Crumhach Wind Farm, Co. Sligo

Stage 1 Road Safety Audit

Alan Lipscombe Traffic and Transport Consultants

August 2026

Figure 15-16 Access Junction C - L2702 / wind farm access, junction layout, blade extended artic

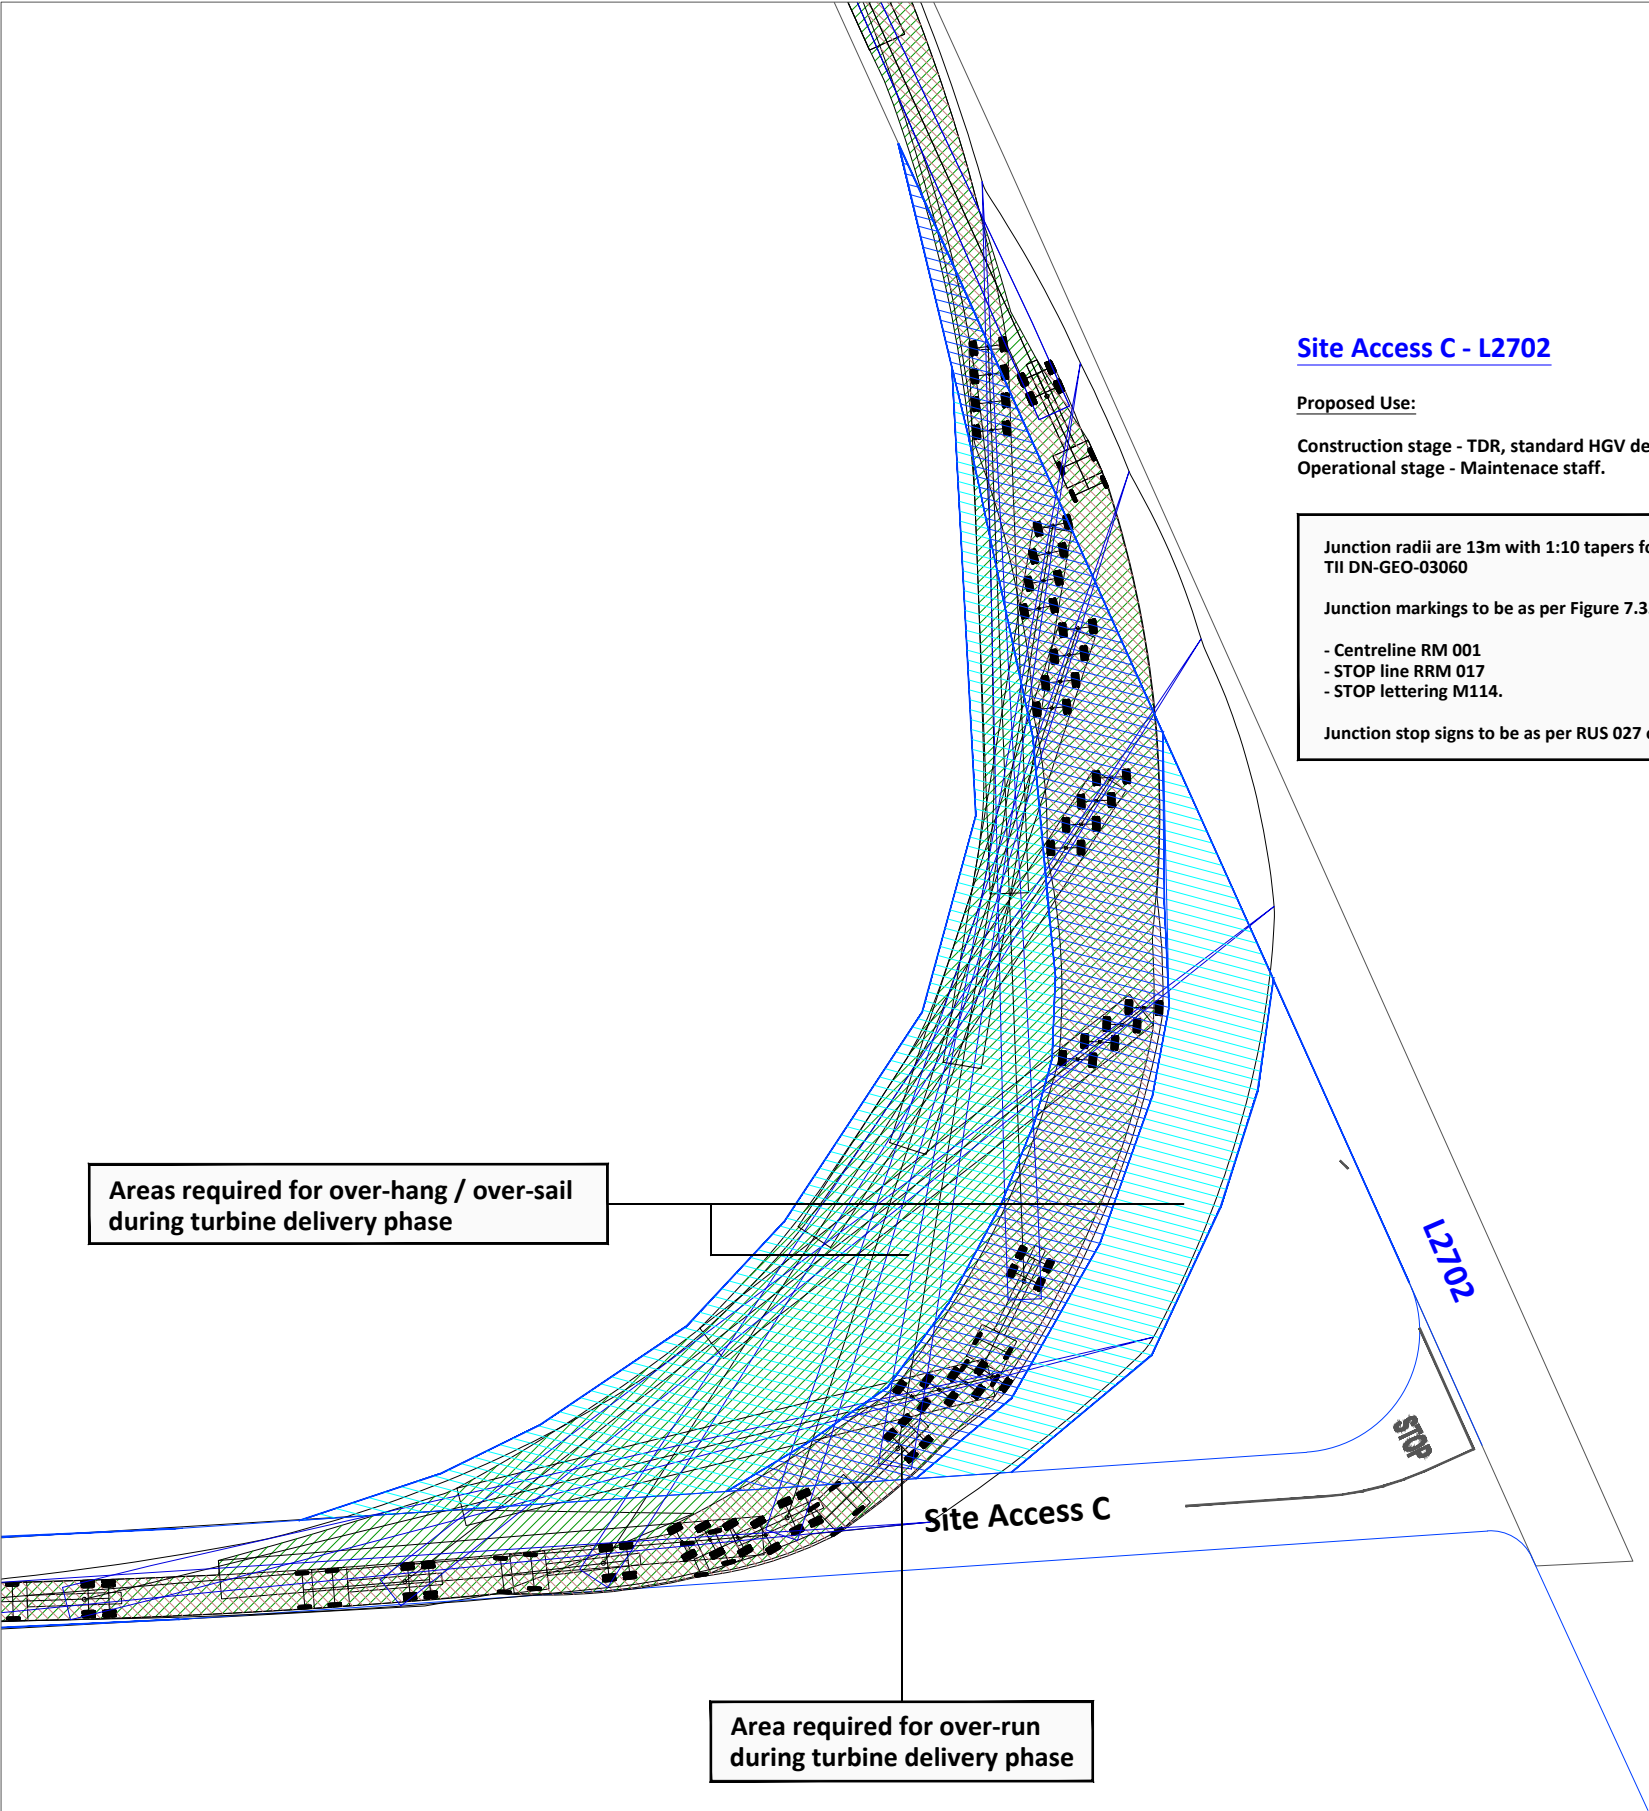
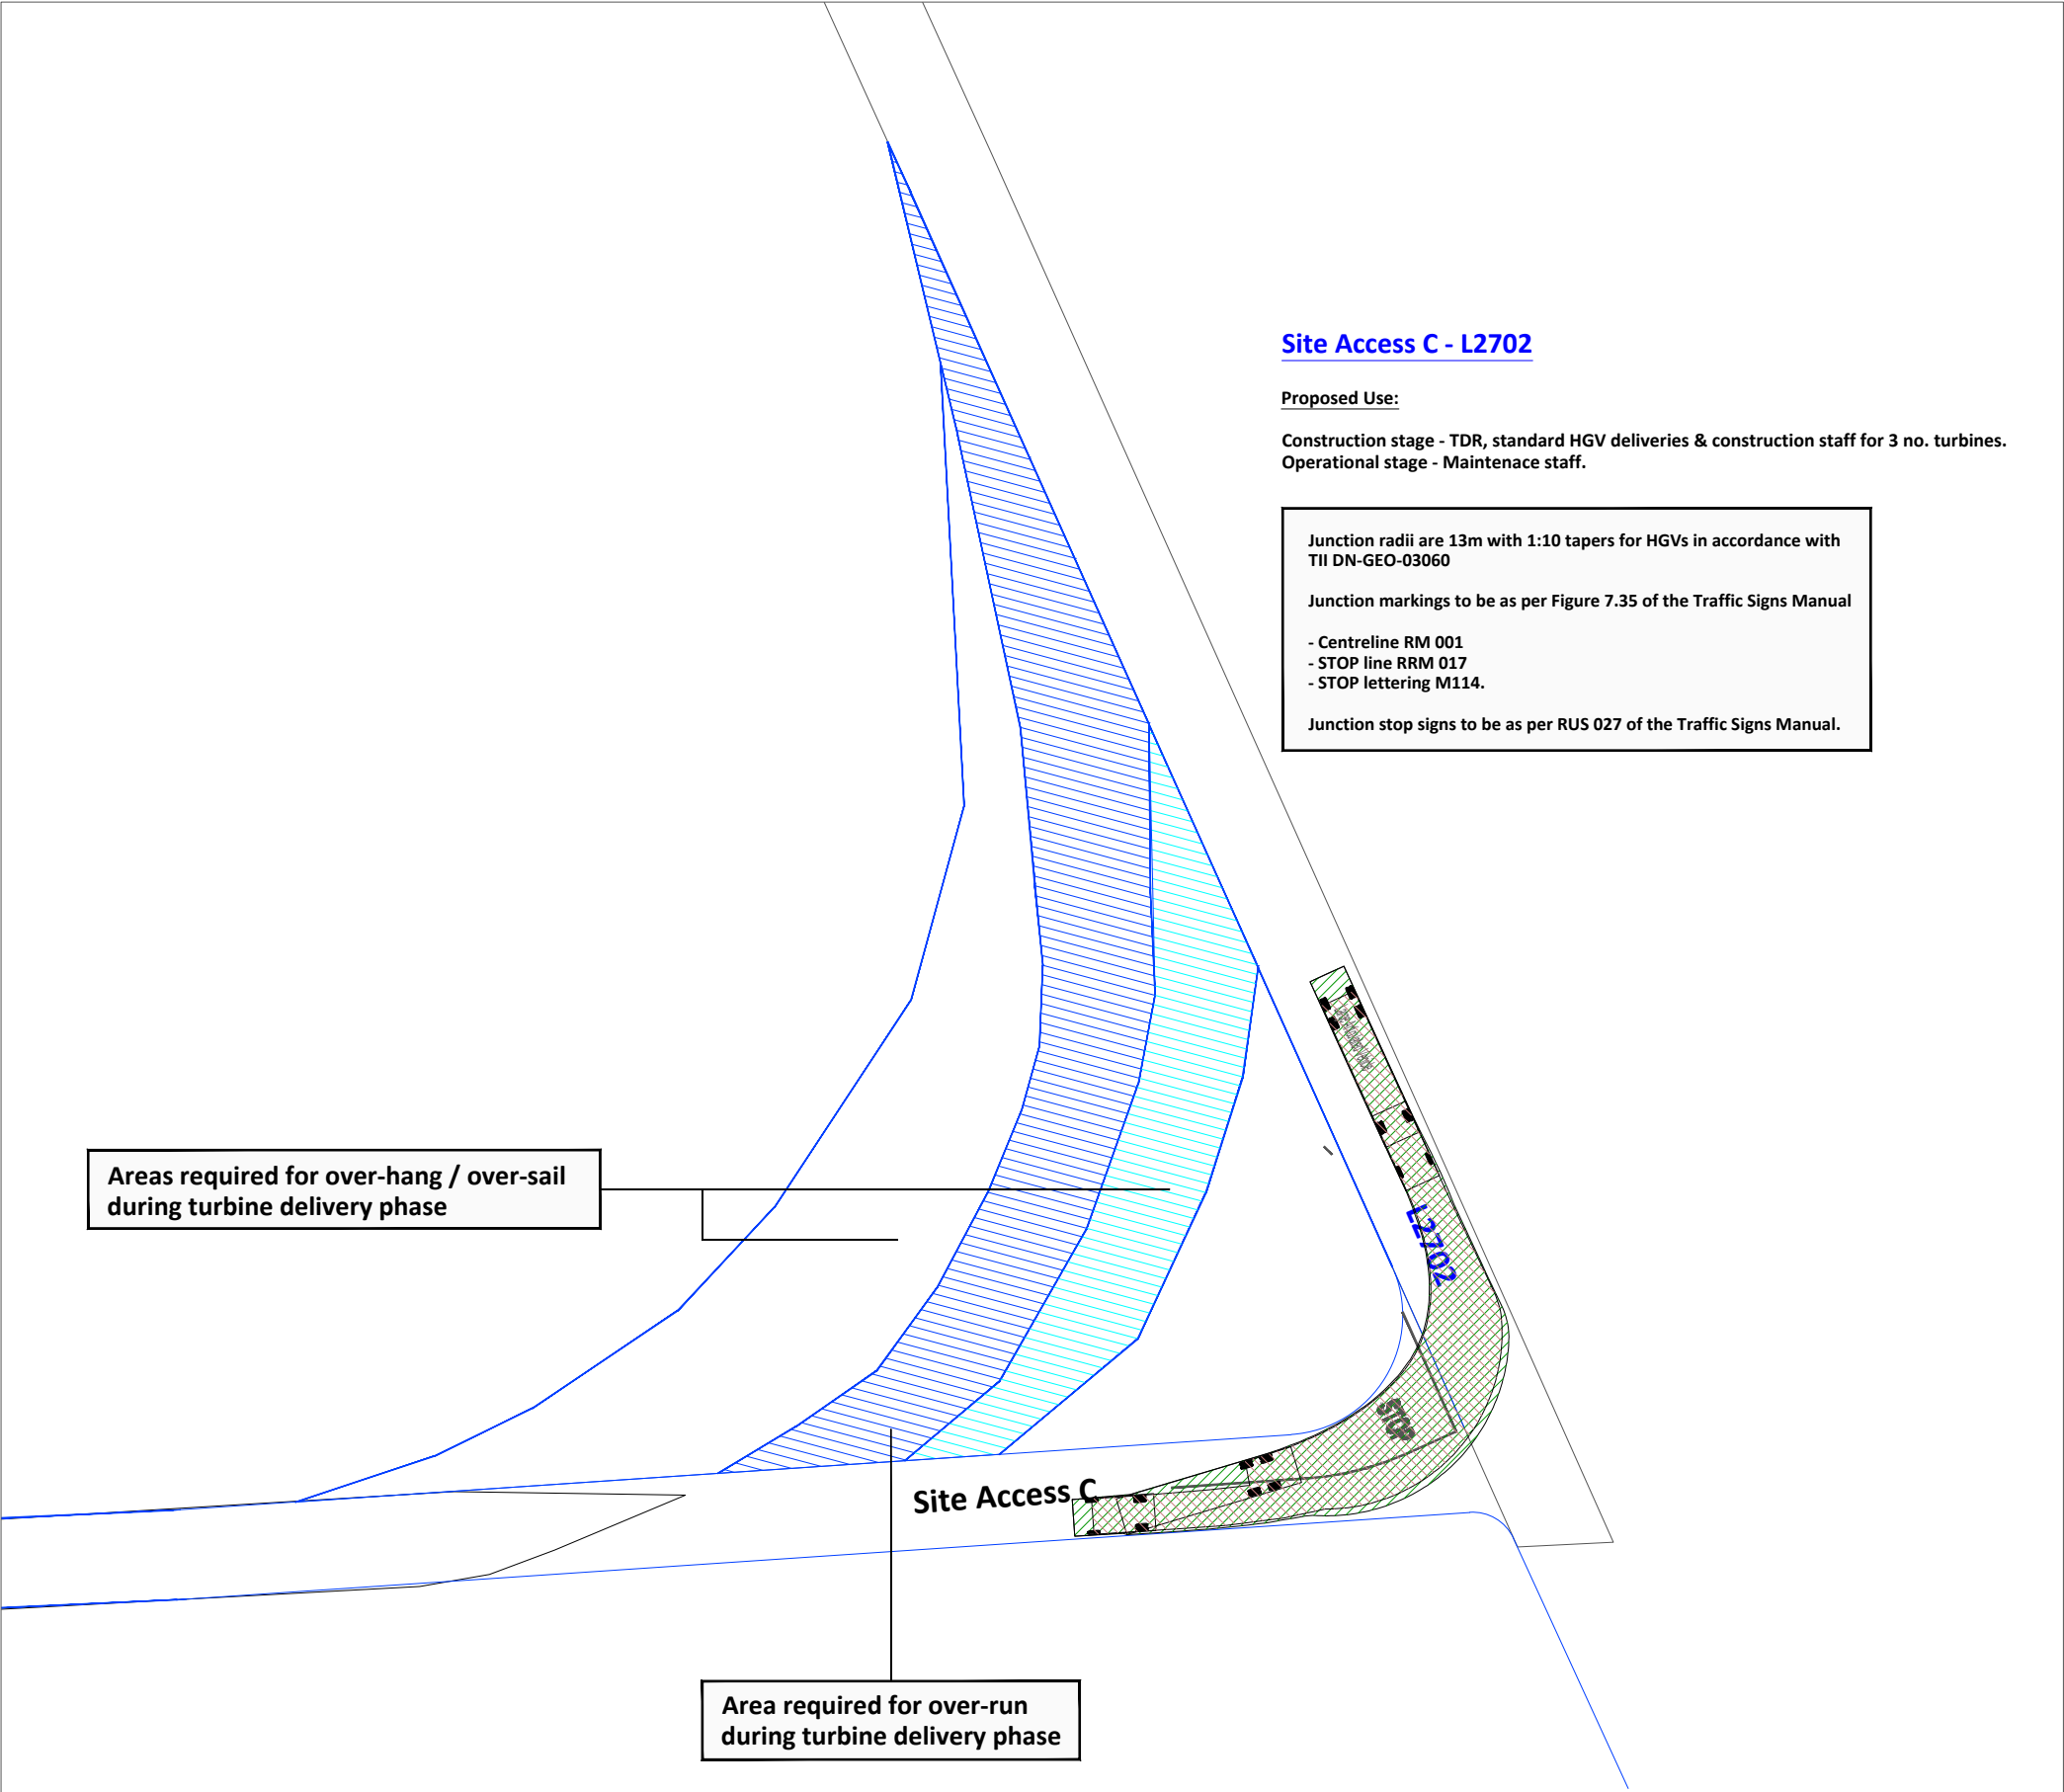
2.3 Problem: Passing Motorists Accessing Vehicle Overrun Area

Location: Site Access C – Local Road L2702

The temporary over-run area might create confusion for passing motorists, who could access it by mistake, leading to sudden braking, loss of control or conflicts with construction traffic.

Recommendation

The Designer should ensure that a suitable barrier is put in place to prevent passing motorists from accessing the abnormal load overrun area when it is not in use.

2.3	Yes	Yes	A suitable barrier will be put in place at all times during the construction stage and opened only on the nights that the abnormal loads are delivered. On these occasions the deliveries will be accompanied by a Garda escort and the opened junction will be attended by site staff. On the completion of construction the over-run areas will be closed off permanently.	Comment noted

Figure 15-23 Access Junction E - L2702 / substation access, junction layout with visibility splays

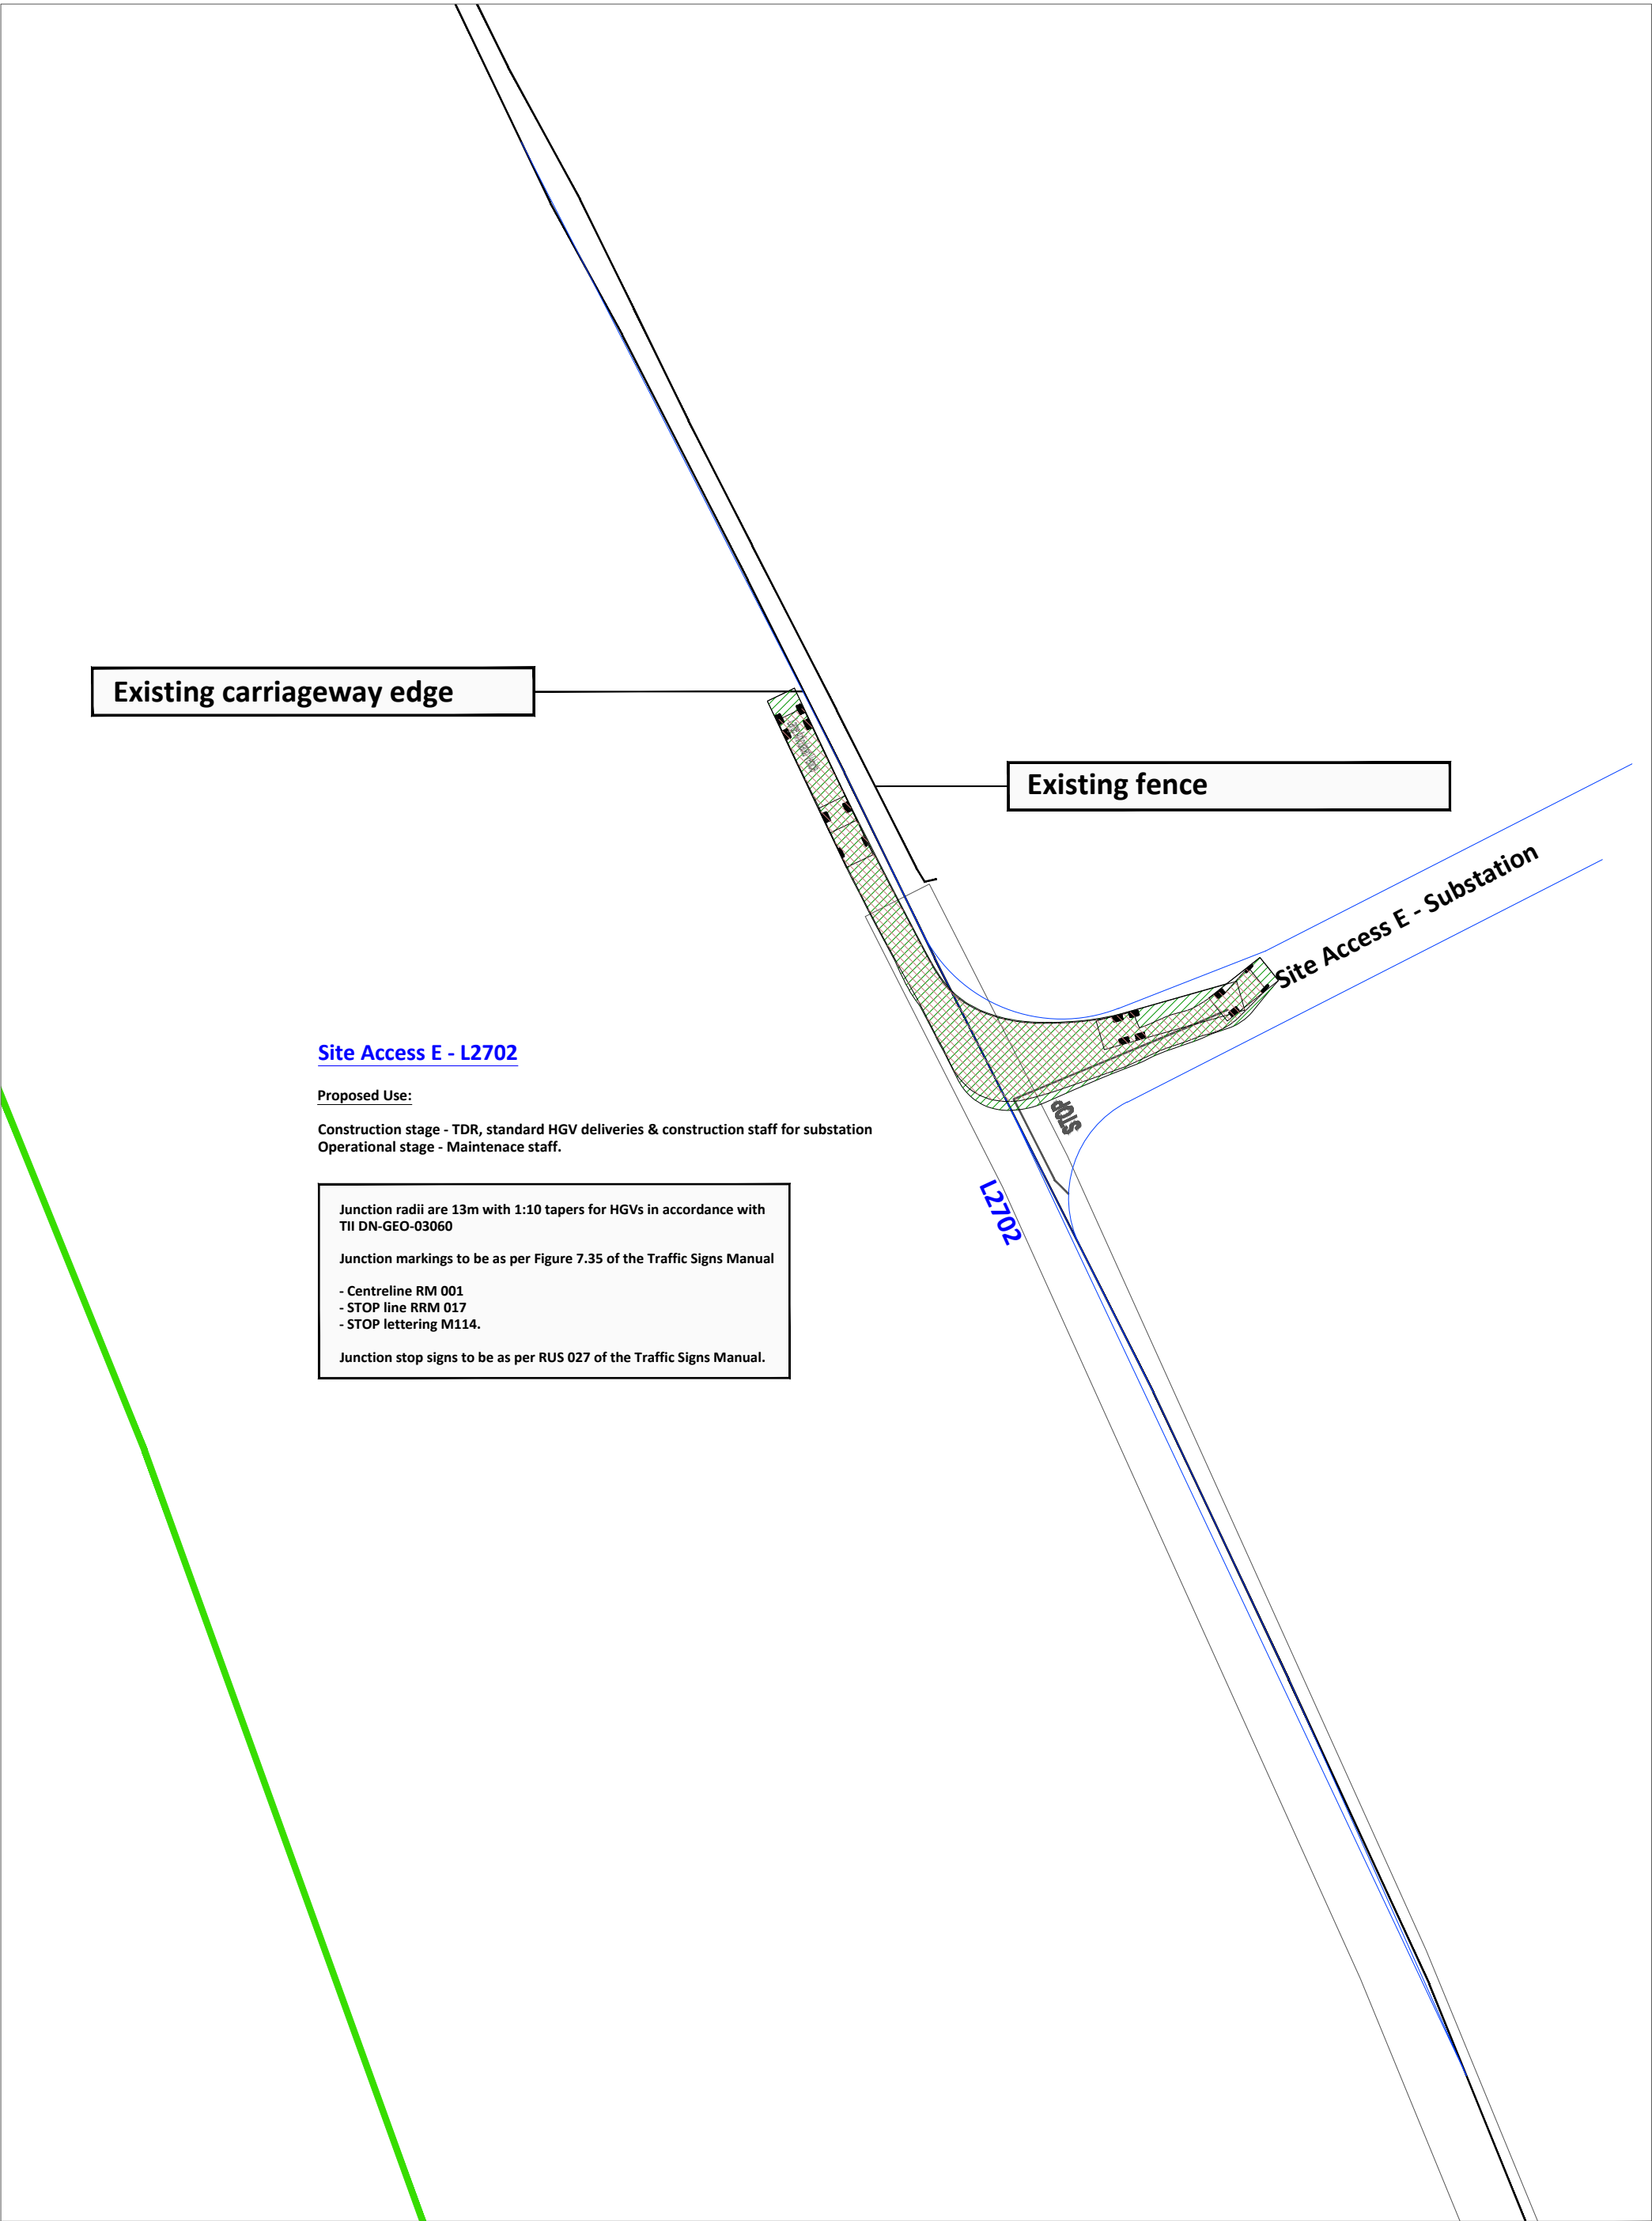
2.5 Problem: Passing Motorists Accessing Vehicle Overrun Area

Location: Site Access E – Connection to Local Road L6309

There is a noticeable level difference between the existing L6309 and the location of the proposed access road. A steep access road in this location could result in vehicles rolling backwards down the incline or stalling as they attempt to join the local road.

Recommendation

The Designer should include a gentle gradient on the access road approach with a suitable dwell area where it meets the local road.

2.4	Access D For Record Purposes Only. No Safety Issues Identified.			
2.5	Yes	Yes	The gradient for the substation access arm of the junction proposed on the L2702 will be raised to be in accordance with guidelines set out in Rural Road Link Design DN-GEO-03031, TII, June 2017, and will include a dwell area of a minimum of 15m which will have a gradient of a maximum of 2.5%.	Comment noted
